Betreft: Morecambe Offshore Windfarm Generation Assets - Transboundary Consultation

The Flemish agency of Agriculture and fisheries would like to react on the progress of the Morecambe Offshore Windfarm Generation Assets - Transboundary Consultation.

The agency does not agree with Volume 5 Chapter 13 Commercial Fisheries and Appendix 13.1 Commercial Fisheries Technical Report in regards to the conclusion of the impact on the Belgian fisheries active in the Morecambe area.

Figure 5.24 Landings from the regional study area by all vessel nationalities 2012 to 2016 (EU DCF, 2022).

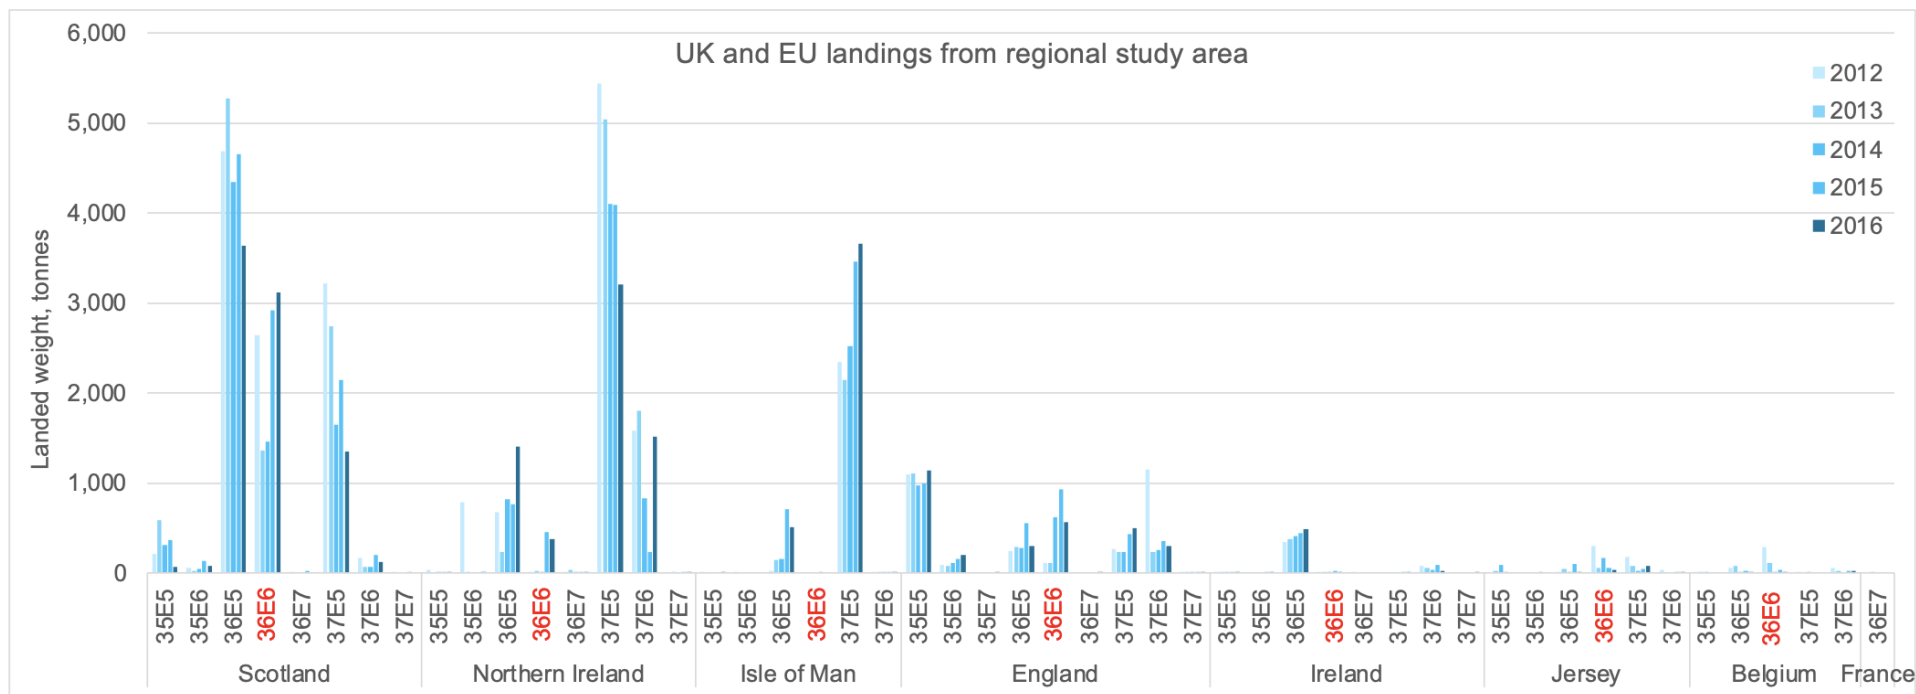
The Morecambe ICES rectangle 36E6 and surrounding area is an important area for the BE fisheries. Between 2019 and 2023 the landings of the area was on average 136 ton which account for at least 1% of the annual turnover of the Belgian fleet. The agency notices that the cited data used in the technical report were from 2012 to 2016, which are not recent data and does not reflect the current activity and importance of the area for the Belgian fisheries. Furthermore recent data suggest the opposite of the cited data and show quite high steady fisheries activity with some fluctuation but no sign of decrease.

Further the Agency is puzzled why there was no mention of any assessment of the possible impact of Brexit on the EU-fisheries within the chapter and the technical report, and due to the use of data before 2020 this is also not reflected in the outcomes.

The Flemish Agency of Agriculture therefore asks to reevaluate Chapter 13 and the conclusions made by the technical report. The Agency would like to continue monitoring the developments and is open to be actively involved in further discussions. We will also always be available to provide additional or more detailed information if needed.
